CITY OF MERCER ISLAND

April 16, 2020

RE: Request for Information – SUB18-008

The City of Mercer Island Community Planning and Development Department has completed its review for compliance with the zoning code, Title 19 of the Mercer Island City Code (MICC) for the preliminary short subdivision application submitted on December 3, 2018, located near 3633 90th Ave SE. The following issues need to be addressed before we can continue processing the application:

SITE PLAN

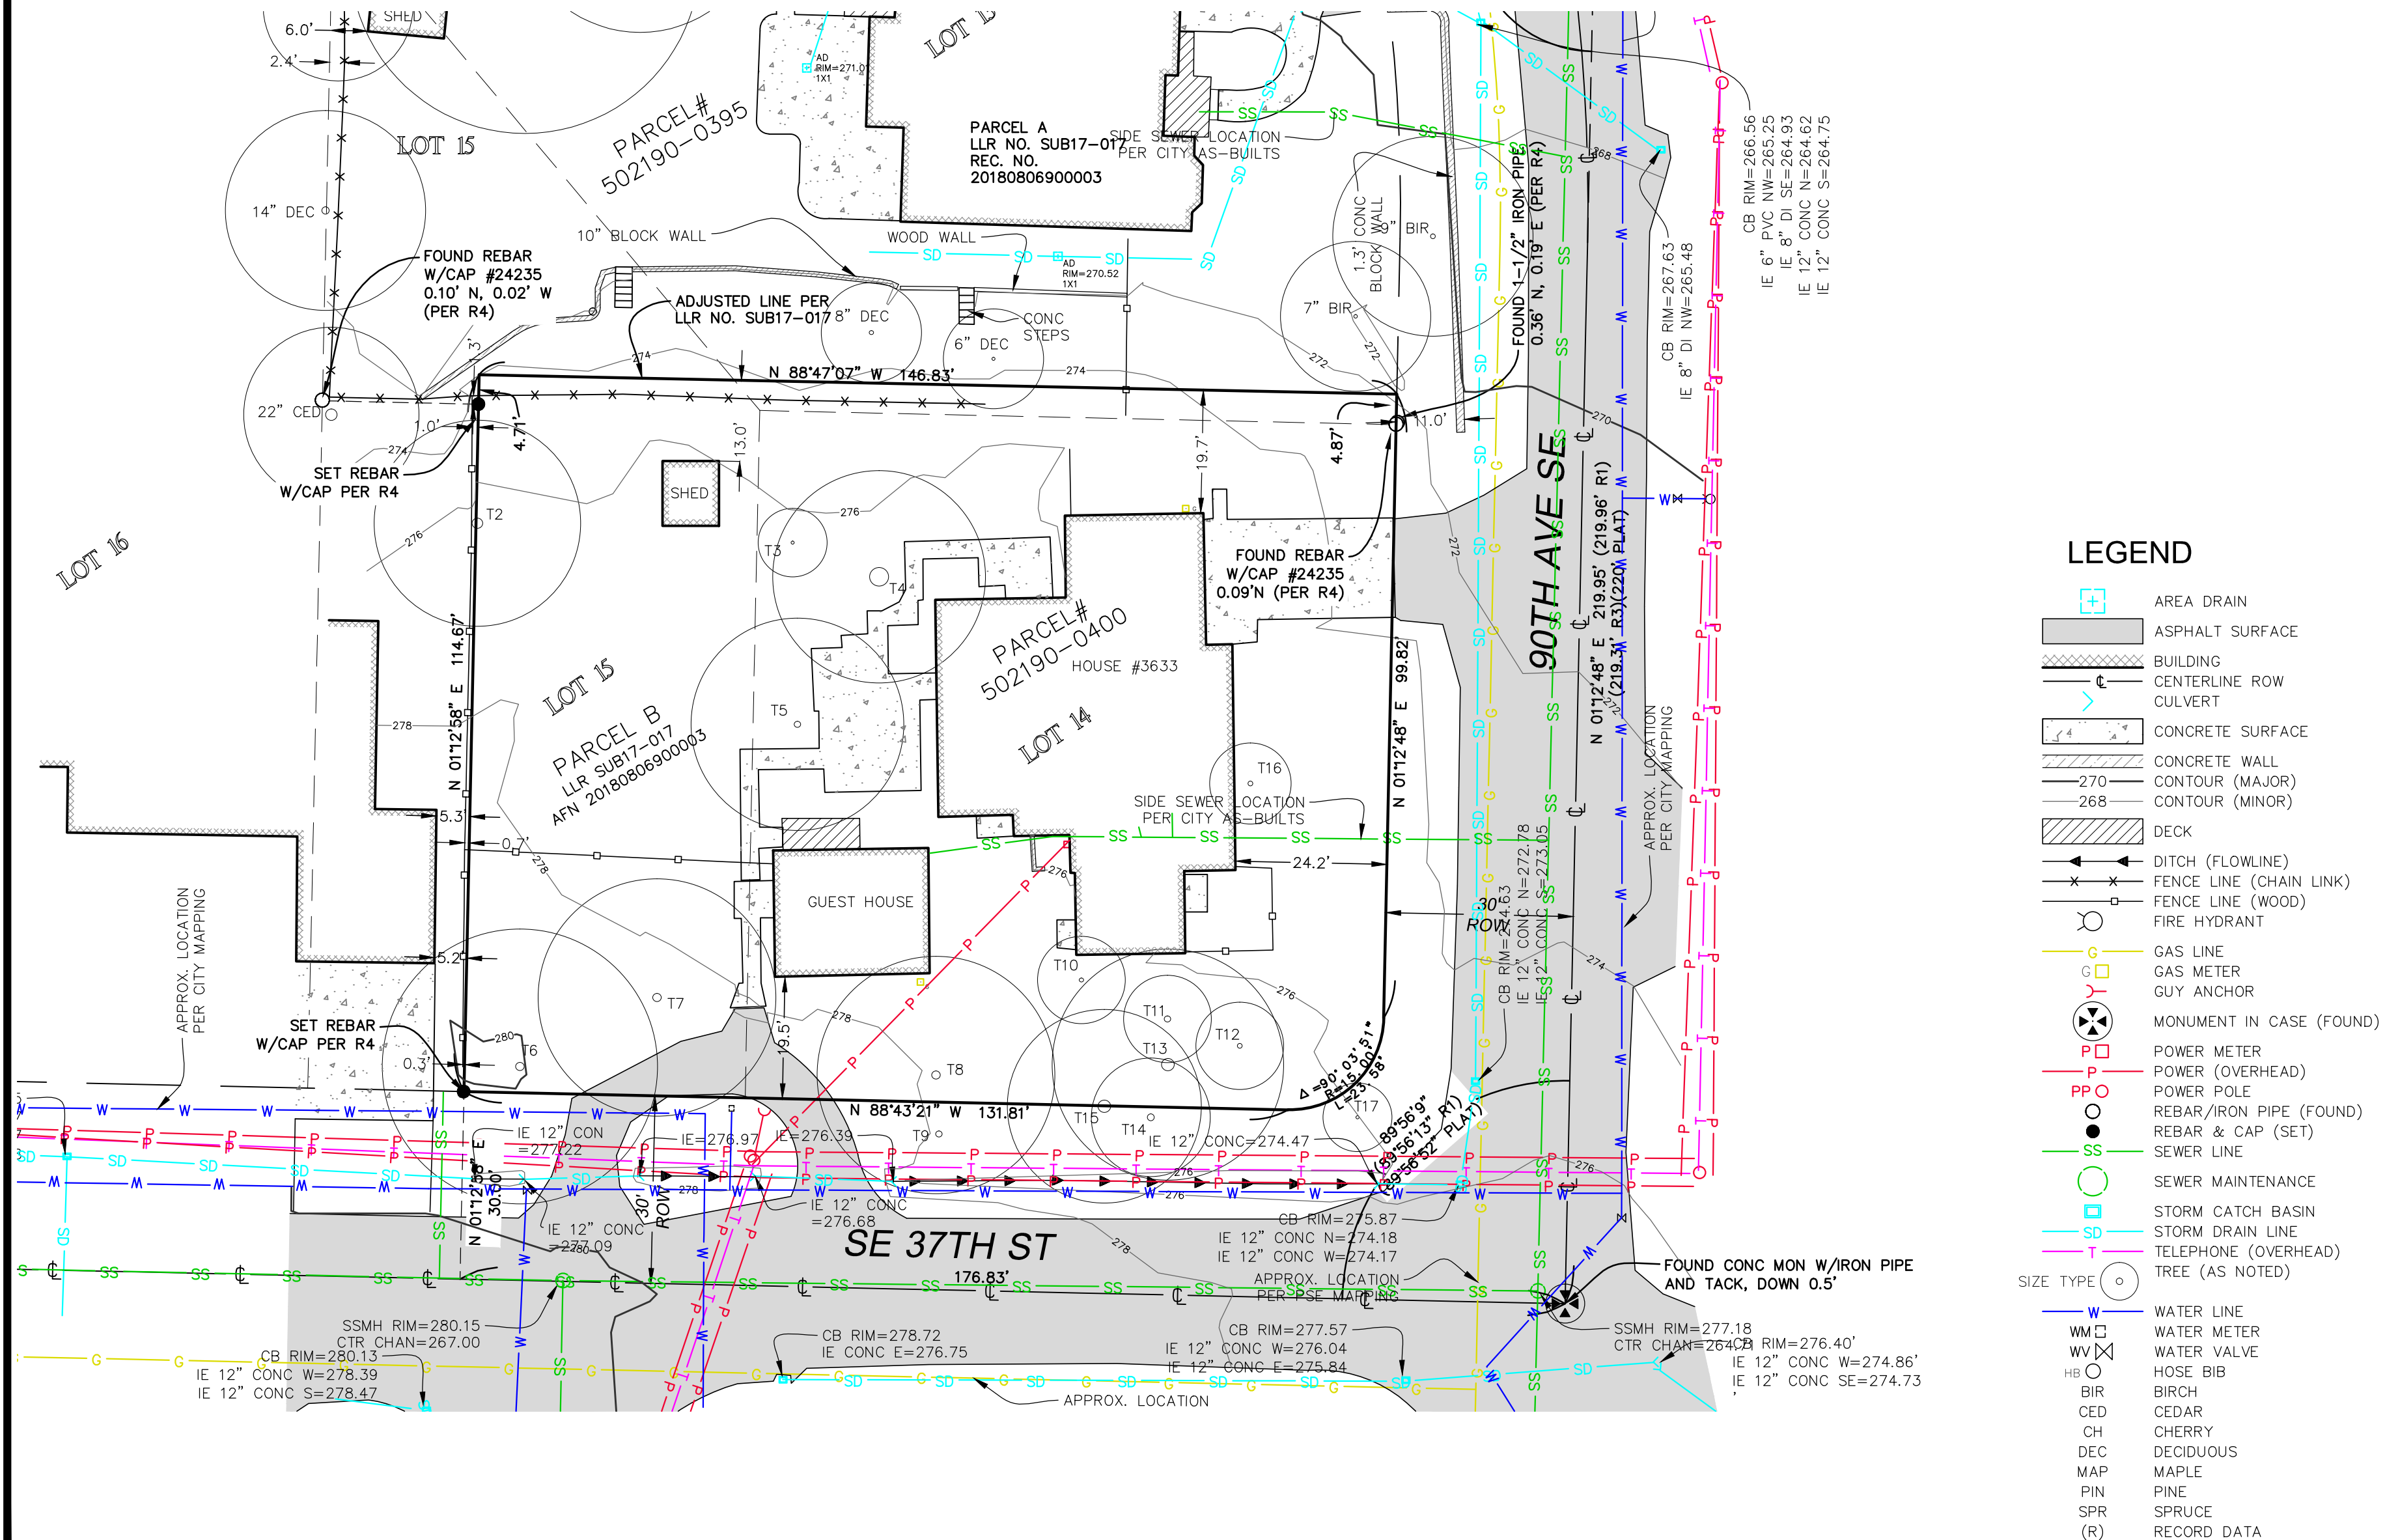
1. MICC 19.08.030(E)(4) states that proposed subdivisions shall incorporate preferred development practices pursuant to MICC 19.09.100 where feasible. MICC 19.09.100(A) requires that development, including subdivisions, shall use common drives and utility corridors where feasible.

The project narrative states that Lots 1 and 2 will access different streets, at opposite corners of the parent lot. The narrative further states that alternate options for a shared drive were explored, but abandoned since they would create additional impacts to the site. However, these additional impacts to the site were not described in detail in the project narrative. Please provide more information about the impacts and why a shared drive is not feasible for Lots 1 and 2 of this subdivision.

SEE RESPONSE TO ITEM #1 ON NEXT PAGE. ADDITIONALLY AN UPDATED PROJECT NARRATIVE IS PROVIDED FOR FURTHER EXPLANATION

THIS ACCESS CONFIGURATION WILL BE NECESSARY TO THE RETENTION OF NUMEROUS TREES BY KEEPING THE DISTURBANCE AREA OUTSIDE OF THE CRITICAL TREE ZONES ON THE TREES PROPOSED FOR RETENTION. ALTERNATIVE ACCESS OPTIONS INCLUDING UTILIZATION OF A SHARED/Common ACCESS ALONG THE NORTH SIDE OF THE SITE WERE DISCUSSED AT THE PRE-APPLICATION CONFERENCE AND HAVE BEEN EVALUATED BY THE CONSULTING ENGINEER, BUT ULTIMATELY THE DEVELOPMENT DESIGN TEAM CONCLUDED THAT IT WOULD REQUIRE ADDITIONAL IMPACT TO THE SITE, INCREASED IMPERVIOUS SURFACES, INCREASED EARTH DISTURBANCE/EXCAVATION AND GRADING, AND THAT UTILIZATION OF THE EXISTING TWO ACCESS POINTS WOULD BE THE LEAST IMPACTFUL AND ALLOW FOR THE LEAST DRIVEWAY IMPERVIOUS SURFACE FOR THE DEVELOPMENT. WHILE A COMMON ACCESS POINT IS TYPICALLY DESIRABLE FOR SHORT PLATS, THIS CORNER LOT, AND THE SURROUNDING DEVELOPMENT PATTERN WILL BENEFIT MORE FROM HAVING THE TWO HOMES ACCESS SEPARATELY. ADDITIONALLY, A SHARED ACCESS FROM SE 37TH ST WAS EXPLORED BY THE DEVELOPMENT TEAM, BUT CONCLUDED THAT IT WOULD NOT BE FEASIBLE DUE TO THE HIGH-VALUE TREES (TREE #12-17) PROPOSED TO BE RETAINED AT THE SOUTHERLY PORTION OF PROPOSED LOT 2. CITY STAFF AGREED WITH THIS PROPOSED SEPARATE ACCESS CONFIGURATION AT THE PRE-APPLICATION CONFERENCE. THE INTENDED/PROPOSED DRIVEWAY LOCATIONS FOR EACH LOT ALIGN WITH THE CURRENT DRIVEWAYS ALLOWING FOR REDUCED IMPACTS TO THE ROW AND THE SITE, MAINTAIN CONSISTENCY WITH THE NEIGHBORING LOTS, AND ARE SHOWN ON THE PRELIMINARY CIVIL PLANS SUBMITTED WITH THE PRELIMINARY SHORT PLAT REVIEW.

TREE RETENTION PLAN

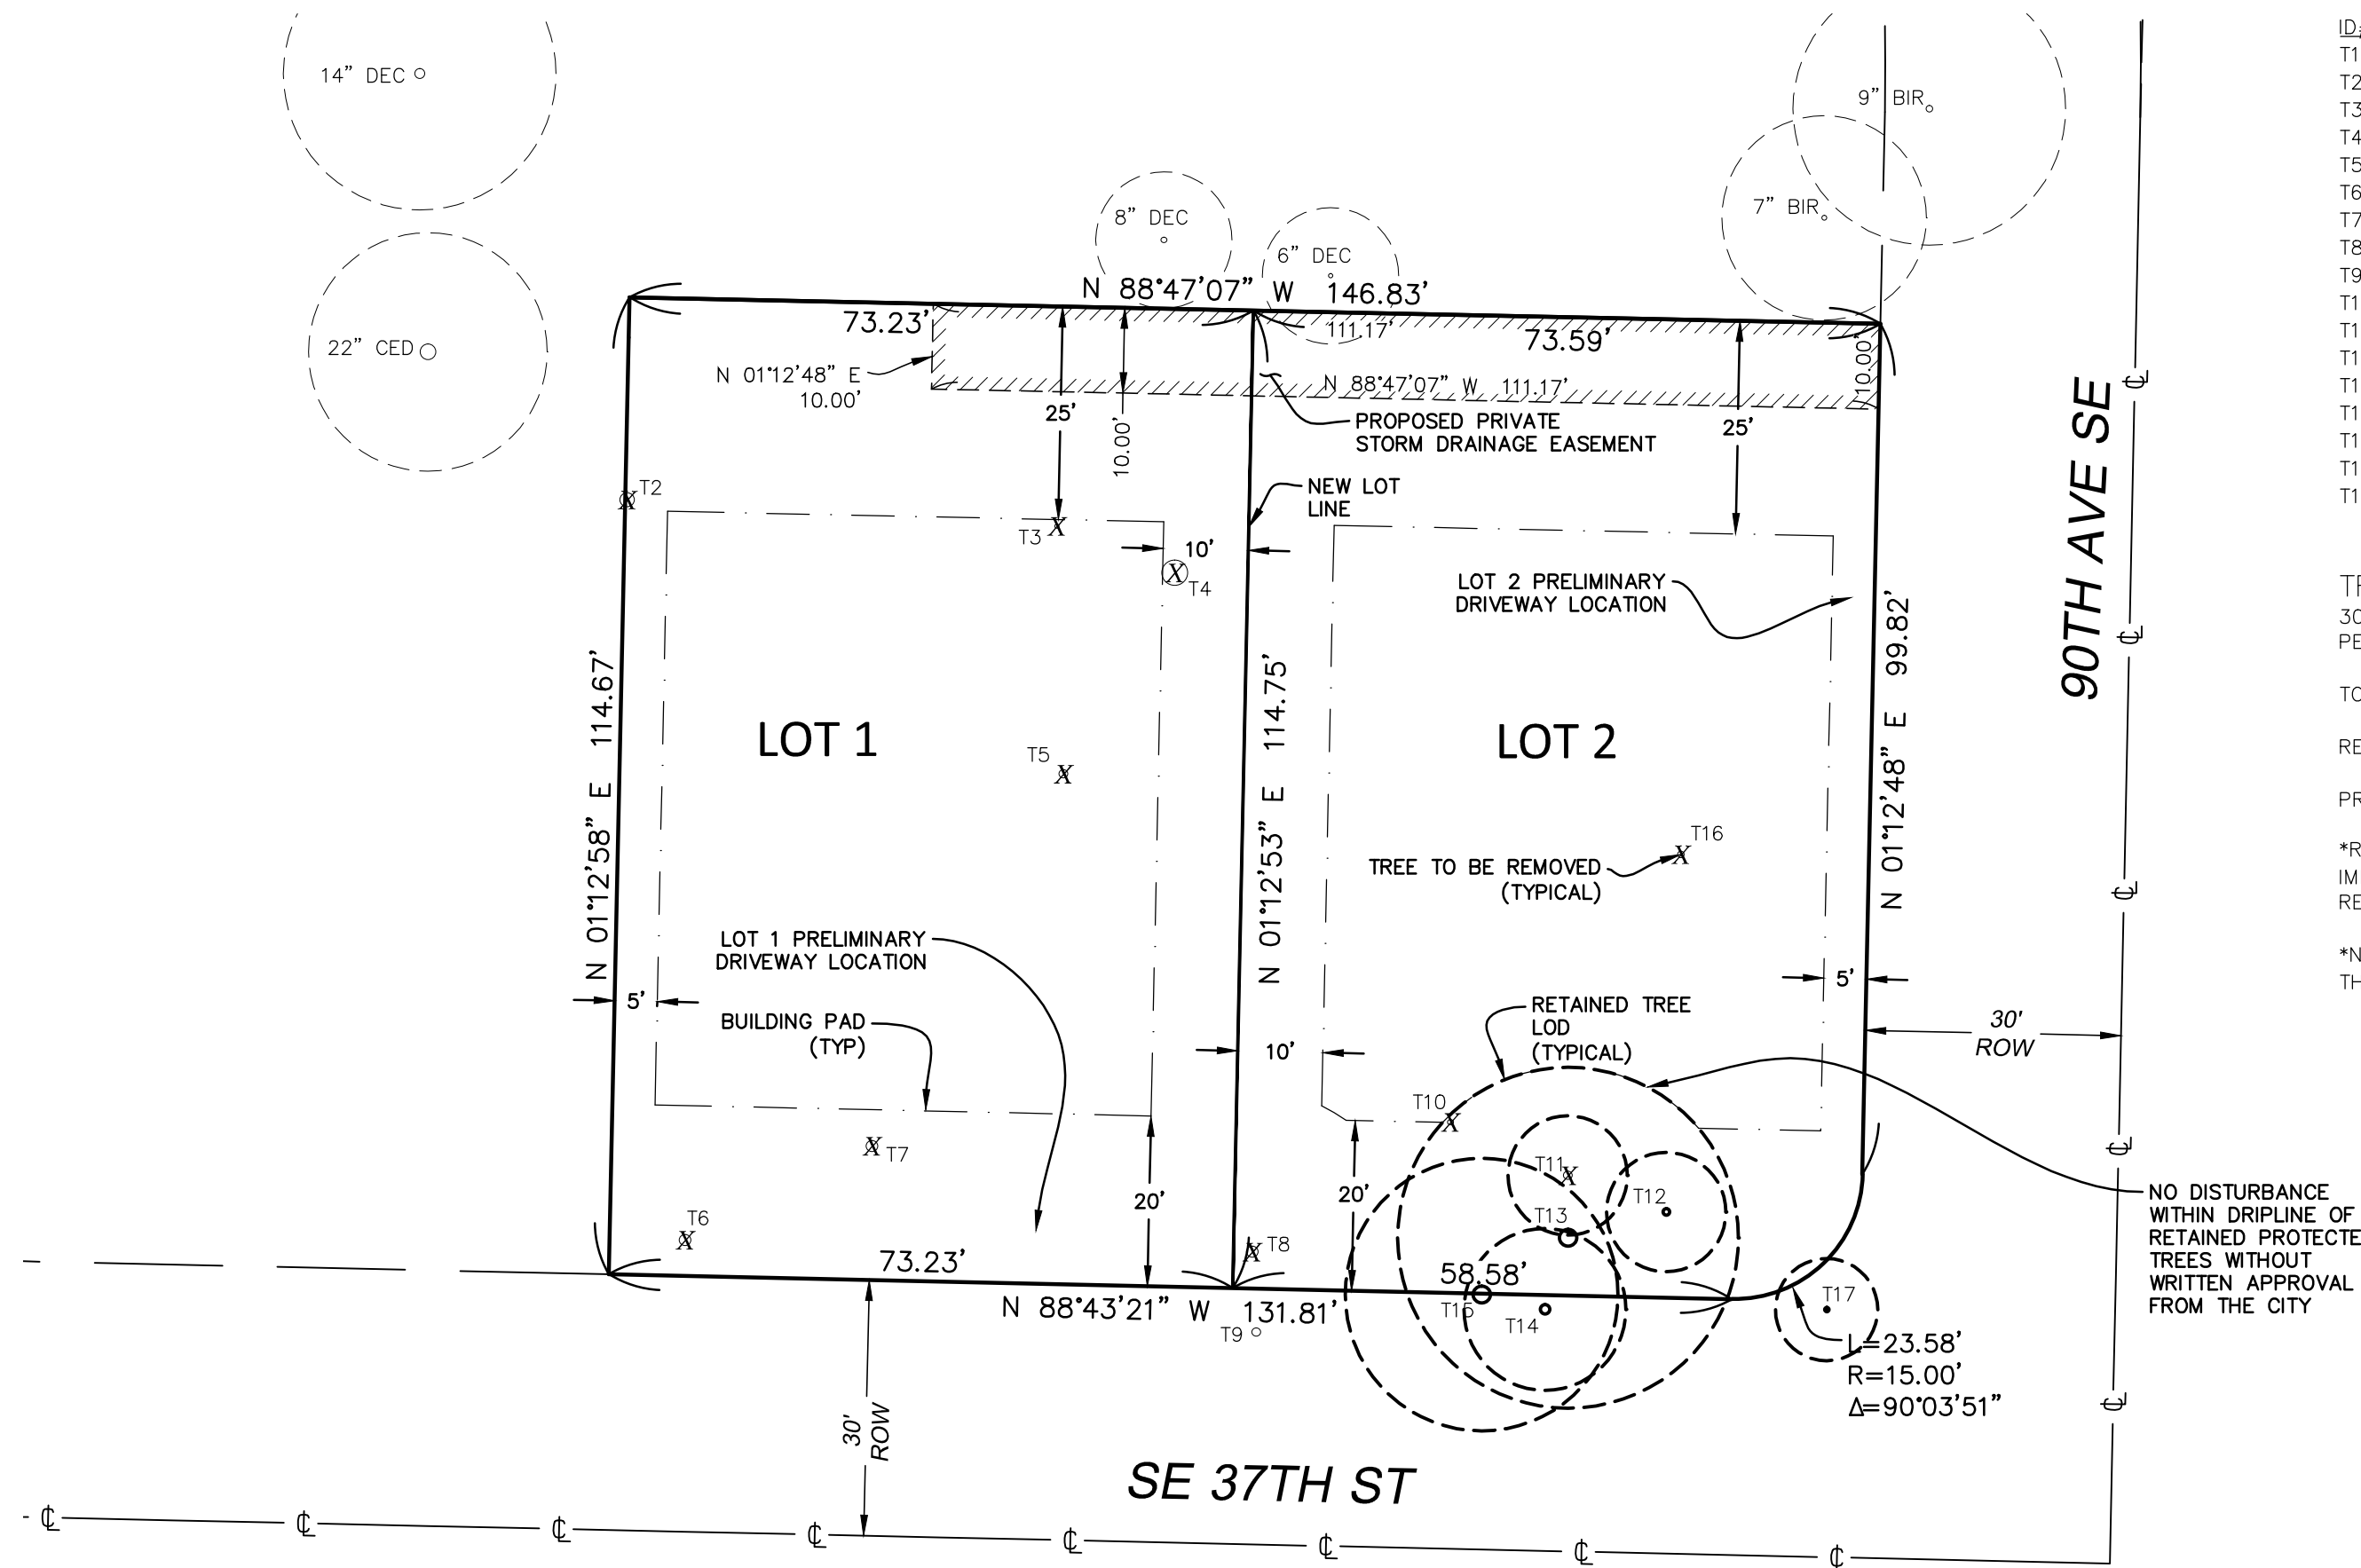
3. Tree 5 is 14 inches and tree 7 is 31 inches. Both trees are exceptional by size unless shown to be non-exceptional because of risk or because they prevent the creation of a lot per MICC 19.10.060(A)(3). The trees are listed as non-viable. Please have the project arborist provide further information on why both of these trees is not viable.

A NEW ARBORIST REPORT HAS BEEN PREPARED AND THE PRELIMINARY SHORT PLAT HAS BEEN UPDATED TO REFLECT THE CORRECTED MEASUREMENTS/TREE INFORMATION
